DECISION DELEGATED TO HEAD OF PLANNING

Application No: H14-0585-26 **Applicant:** Mr K Whincup
Proposal: Erection of implement store and welfare pod
Location: Land North-West Of The Chestnuts Glenside South Pinchbeck
Terminal Date: 21st August 2026

Pre-Development Plan Baseline Map

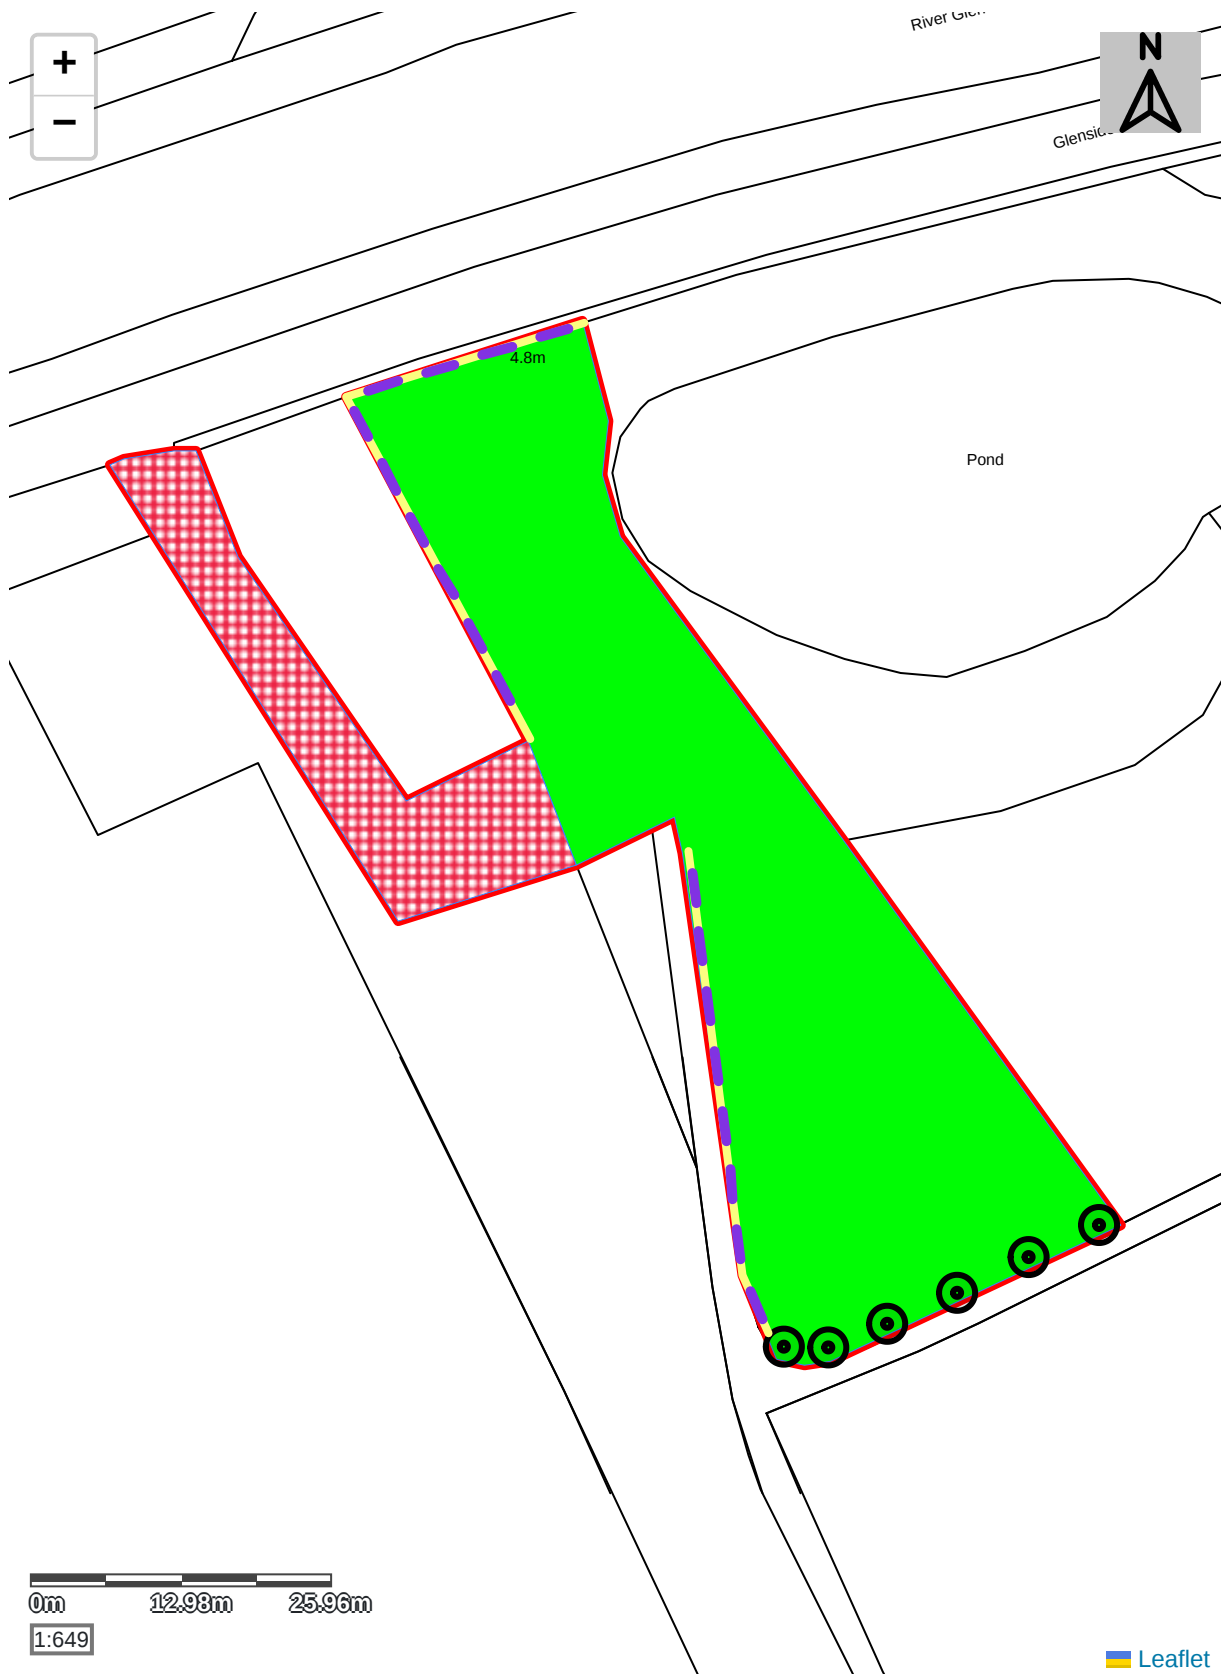
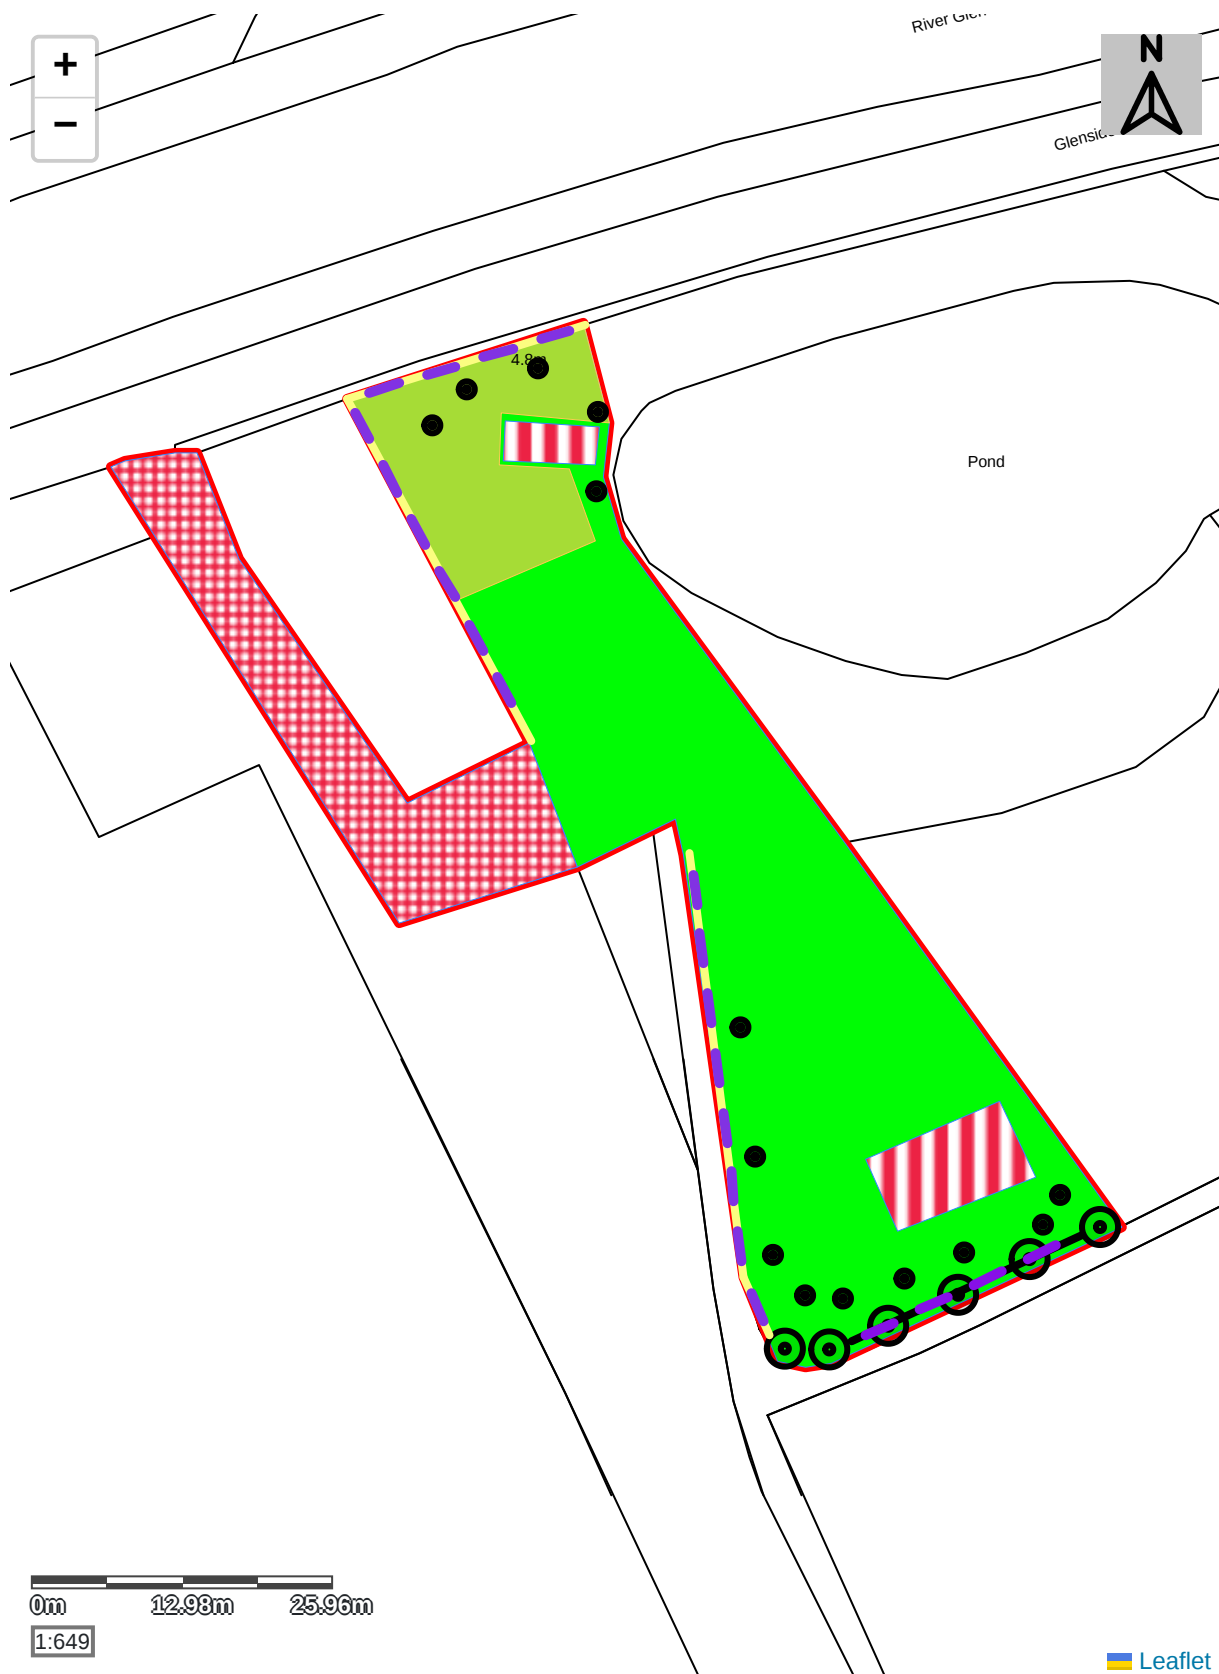
1. The current small-sites metric records the baseline grassland habitat as "modified grassland" (default "moderate" habitat condition), however, the previous BNG report provides evidence that this is a "good" condition modified grassland, and therefore the current small sites metric is not accurately capturing the baseline biodiversity value of the site.

2. It also appears likely that the grassland may have had a higher biodiversity value prior to the vegetation clearance works and initial habitat survey undertaken in 2025. For example, the plant species recorded in the LWS assessment of the site is in excess of 40 species.

3. In addition, older satellite imagery indicates that some small areas of scrub have been removed (see figures 1- 5 below depicting changes in grassland and scrub extent). In both cases, these groundworks and habitat changes were not part of a pre-existing permission, and therefore, the baseline biodiversity value of the site should be taken to be how the site looked prior to 30 January 2020, prior to habitat degradation as defined by the Environment Act 2021 and the Levelling up Regeneration Act 2023.

In this case, I argue that the applicant must provide an updated baseline habitat map and full statutory metric assessment that is representative of the area within the red-line boundary prior to 30 January 2020 (e.g., see figure 5 below). Based on the plant species recorded in the LWS submission, I suggest a conservative approach would be to record the baseline habitat of the grassland as "Other Neutral grassland" in "good" condition, as well as included the small sections of Hawthorn scrub present prior to clearing.
